DECISION DELEGATED TO HEAD OF PLANNING

Application No: H02-0033-26 **Applicant:** Mr M Woodroffe
Proposal: Construction of new detached dwelling
Location: Land To Rear Of 53 West Street Crowland Peterborough
Terminal Date: 16th March 2026

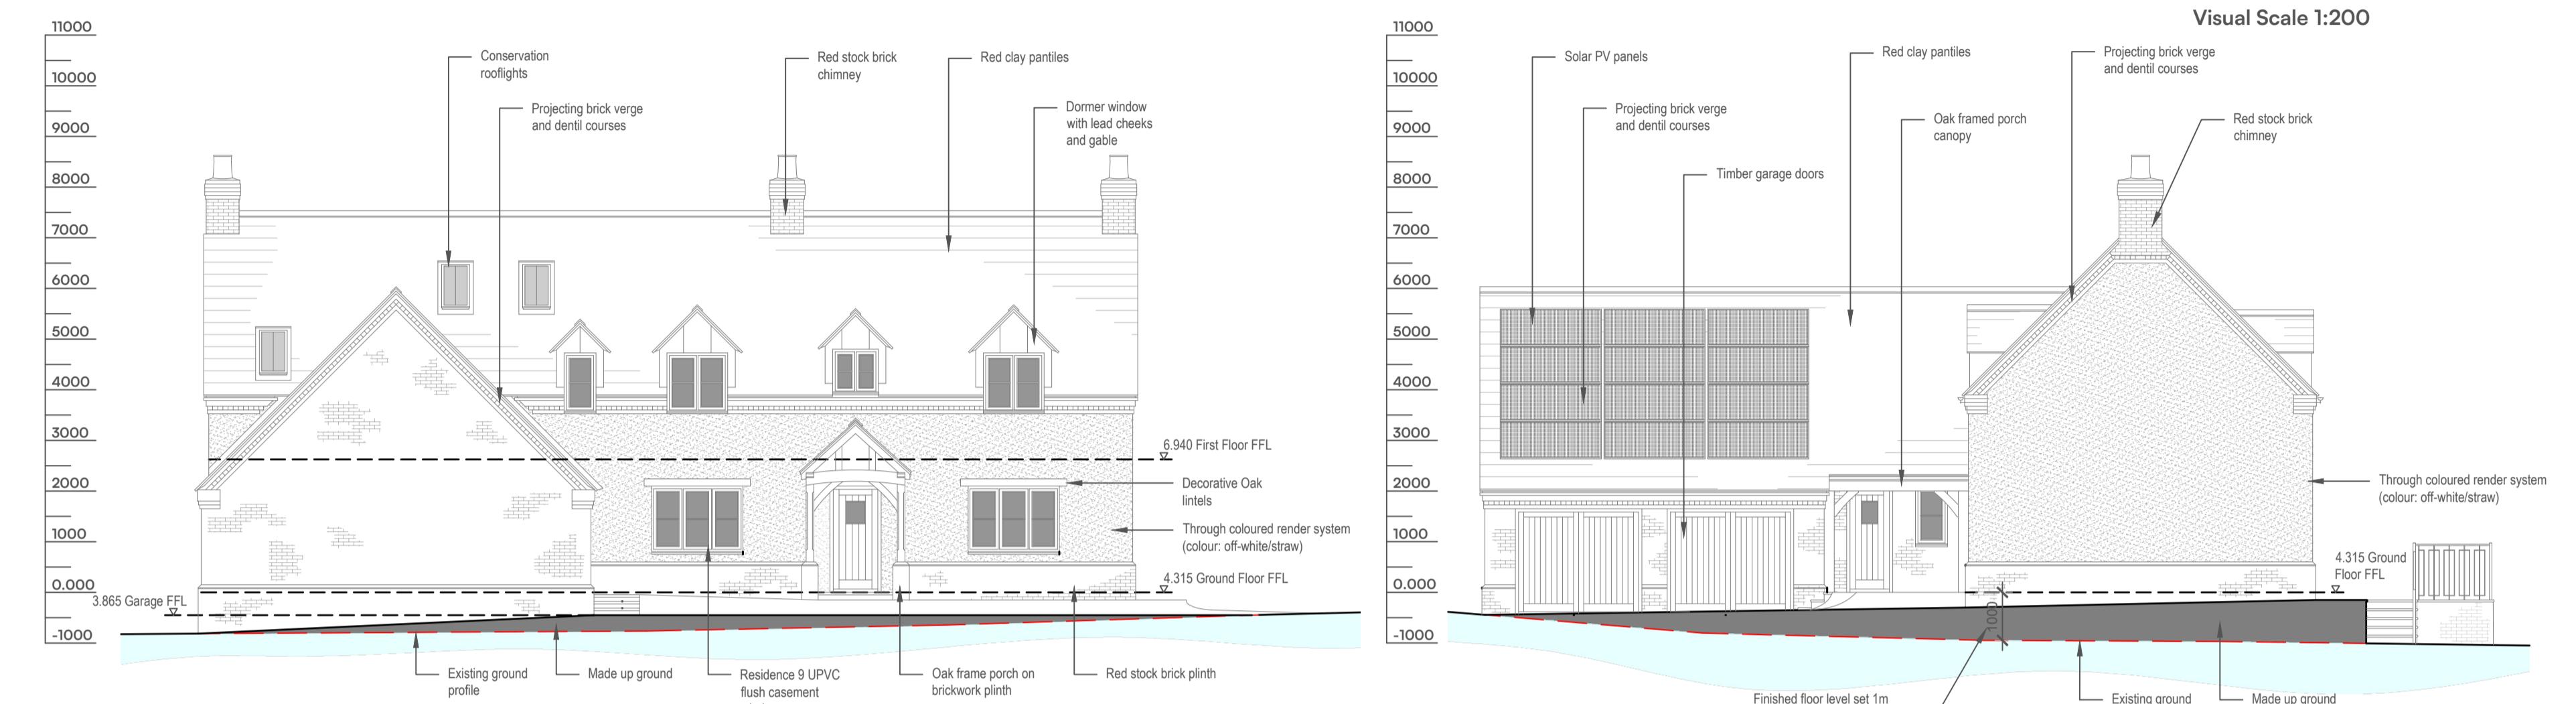
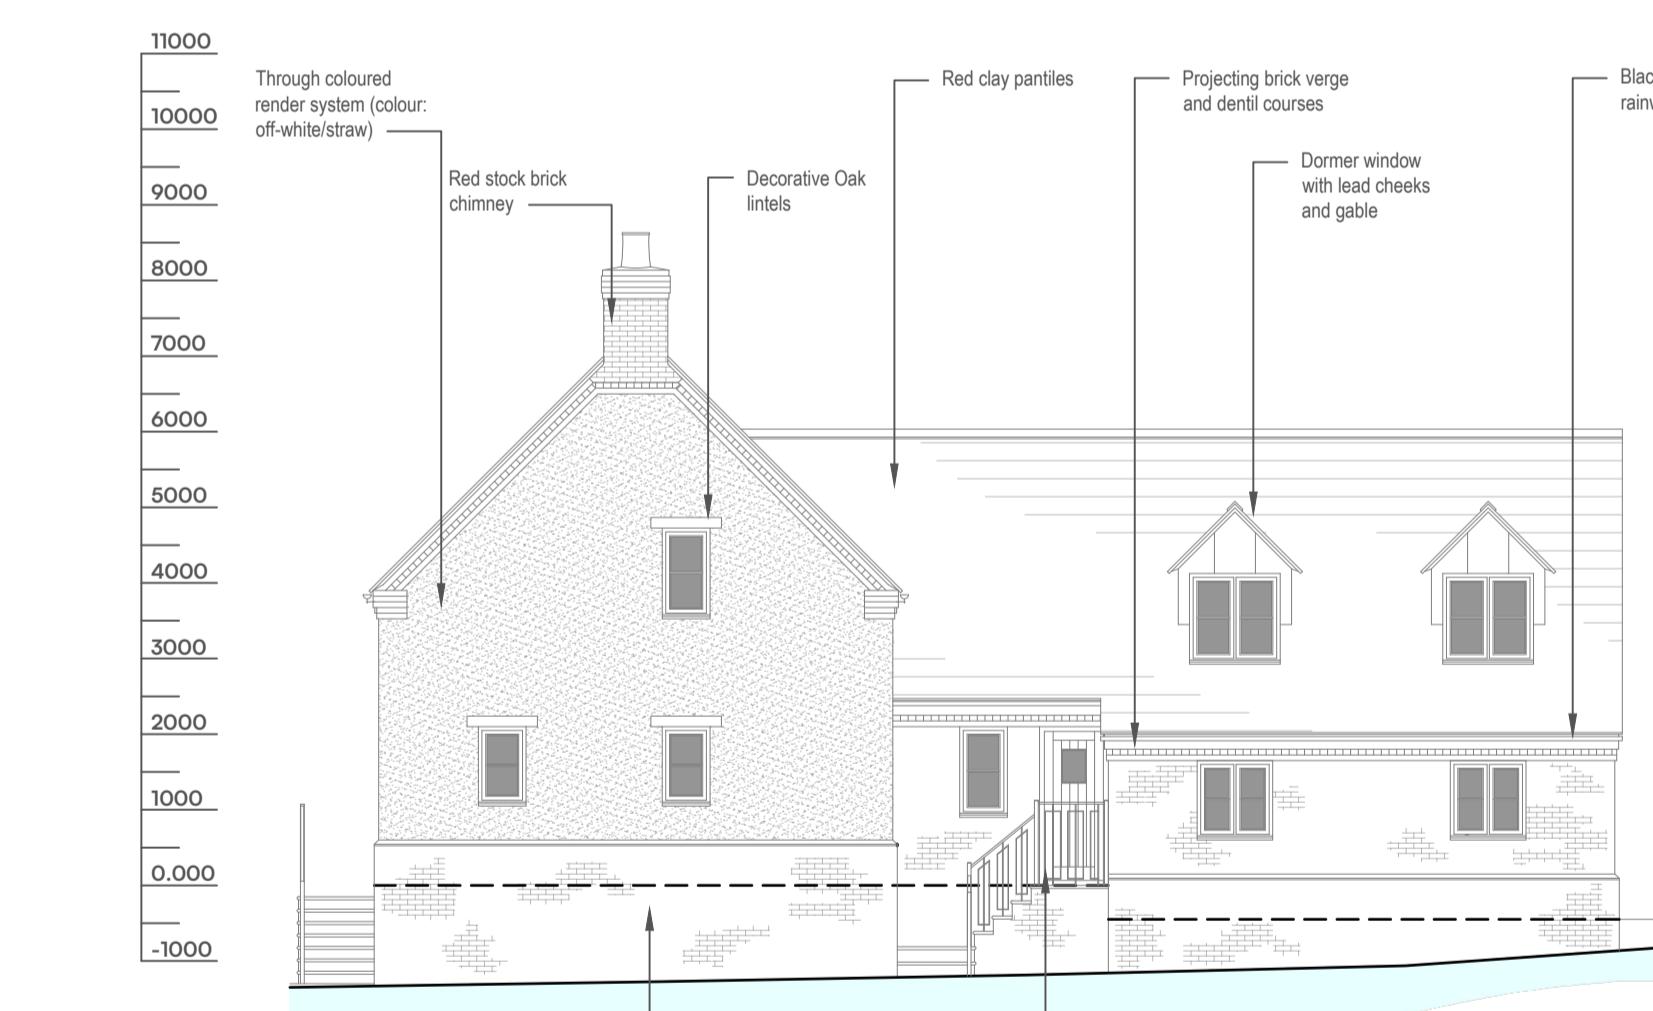
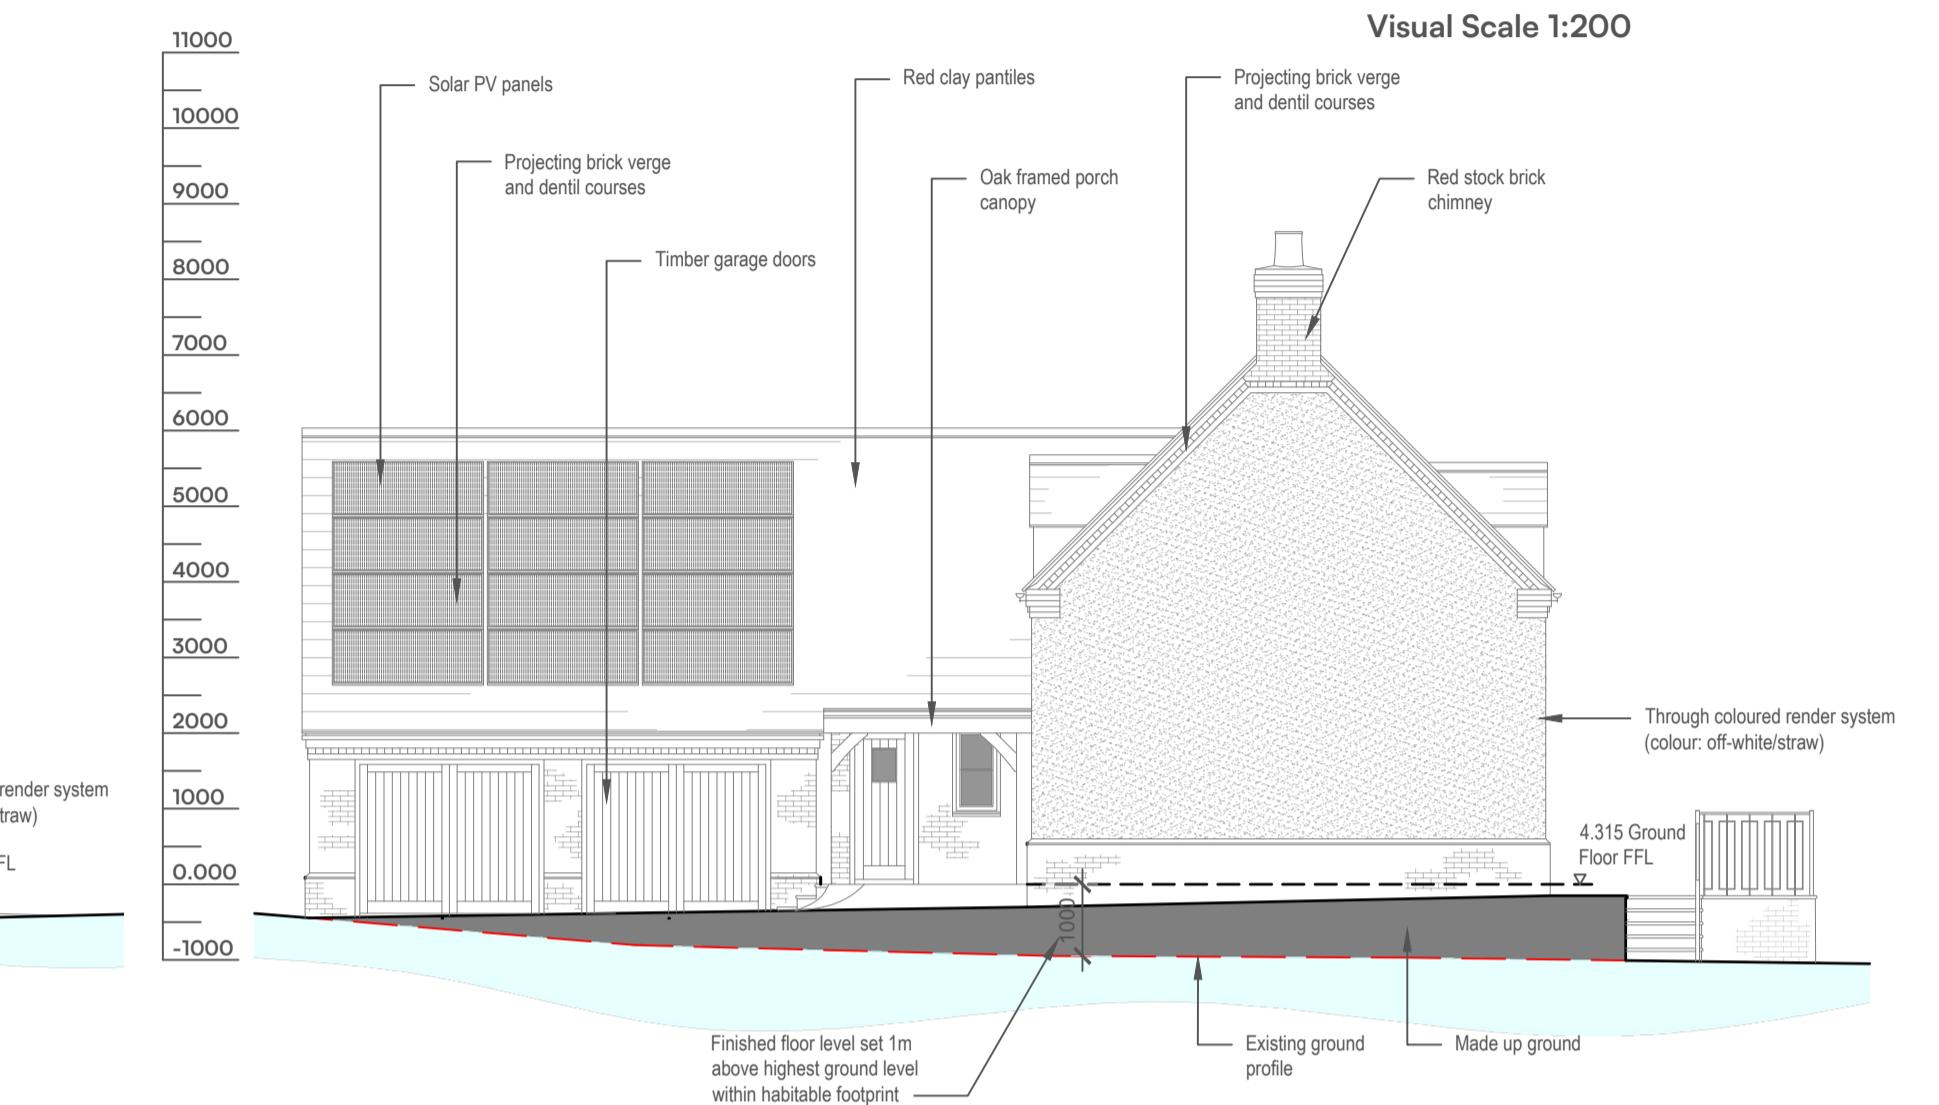
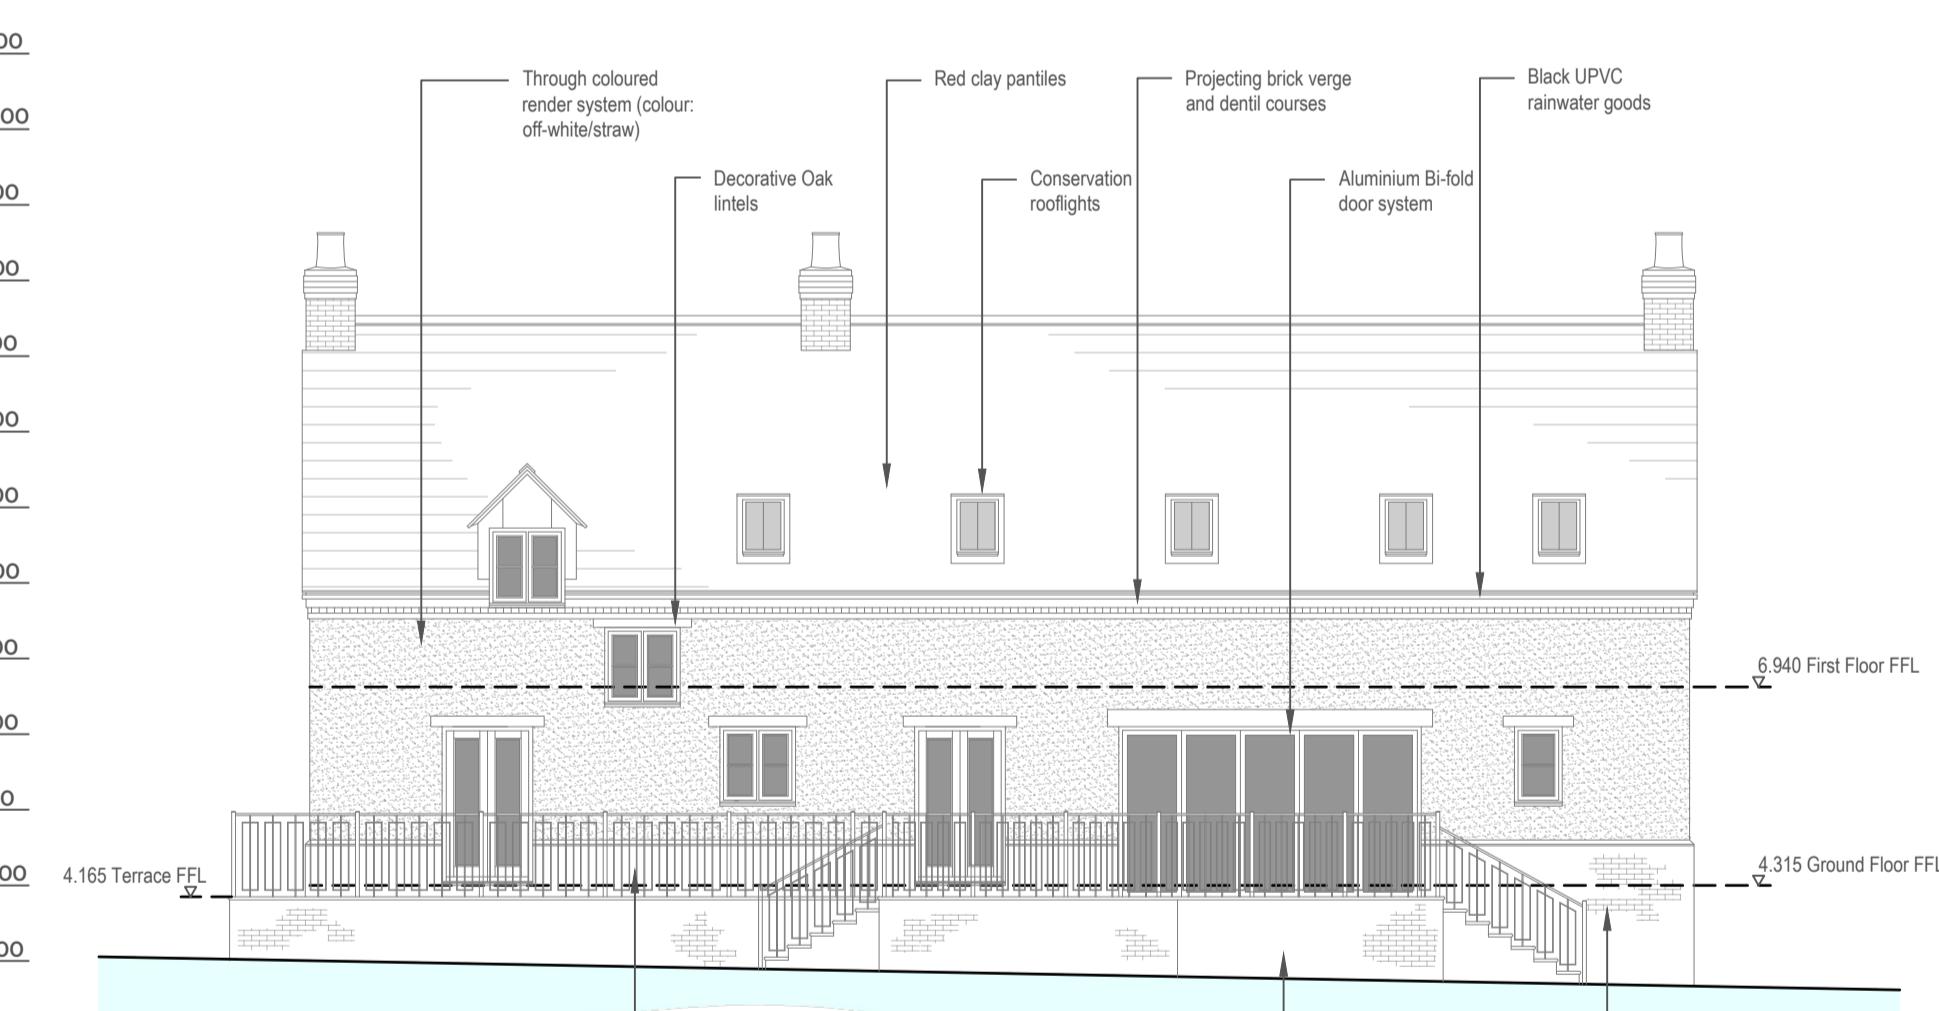
A raised terrace area is proposed along the eastern side of the dwelling and various habitable room windows are also proposed on this elevation, facing towards 32 West Bank. The raised terrace would be approximately 1m above the ground level and the terrace would be located approximately 1m from the eastern boundary in some places. A 1.8m high timber fence is proposed with a 300mm top trellis section along part of the eastern boundary; however, it is considered that the placement of the raised terrace in such close proximity to the eastern boundary would result in an unacceptable degree of overlooking with 32 West Bank, which is located to the east of the site.

The separation distances between the eastern elevation of the proposed dwelling and the nearest elevation of 32 West Bank vary from approximately 13m up to 15m. There are habitable room windows on the eastern elevation and there appears to be habitable room windows on the western elevation of 32 West Bank that would face towards each other. Generally, a suitable separation distance between habitable rooms is considered to be 21m; however, this distance increases where land levels vary. In this case, the higher level of the habitable room windows would worsen the degree of overlooking with 32 West Bank, resulting in an unacceptable impact.

The northern elevation of the dwelling faces towards some of the rear garden of 34 West Bank. Habitable room windows are proposed on this elevation and due to the required finished floor levels, these windows would inevitably result in some loss of privacy of the rear garden of 34 West Bank. Notwithstanding this, it is considered that there would be a suitable separation distance between the northern elevation of the proposed dwelling and any habitable room windows on 34 West Bank.

Furthermore, the overall scale of the dwelling is also considered to be out of keeping with the area and as such, the visual impact of the development is considered to be unacceptable. Therefore, in visual and amenity terms, the proposals do not accord with Policies 2 and 3 of the Local Plan and Section 12 of the NPPF, which amongst other things, seek to ensure that the design of all development is appropriate to the character and quality of the area

SECTION THROUGH WEST BANK - NORTH - SOUTH

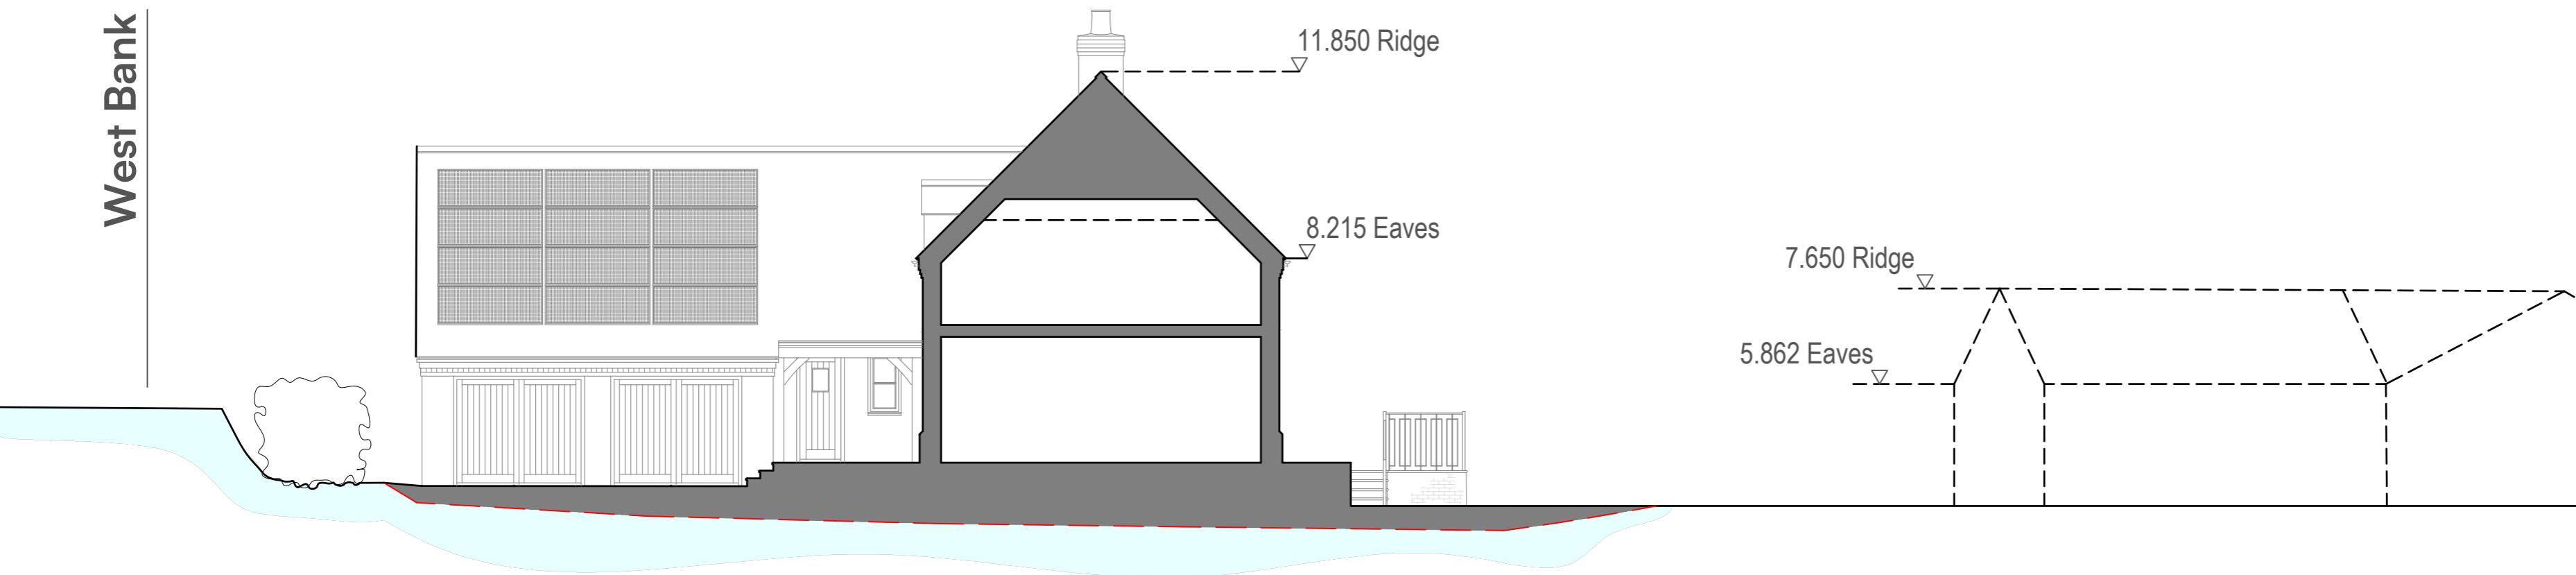
Whilst the site levels vary, the site is set on lower ground compared to West Bank. The submitted Flood Risk Assessment sets out that the finished floor level shall be set no lower than 4.315 metres above Ordnance Datum (mAOD). This means that the dwelling is proposed to be raised up within the site and external stairways are proposed to enable access into the dwelling. The ridgeline height is proposed to be set at 11.85mAOD, which is taller than most of the nearest dwellings which mostly comprise single storey bungalows or dormer bungalows. The overall scale of the dwelling would be much larger than the dwellings within the adjoining plots. Whilst the submitted sections plan (04 Rev A) shows a view of the site from West Bank which shows the dwelling set within the site on lower ground; however, the dwelling would be visually prominent from other surrounding viewpoints such as from the north of the site on the approach along West Bank where views of the site are more open.
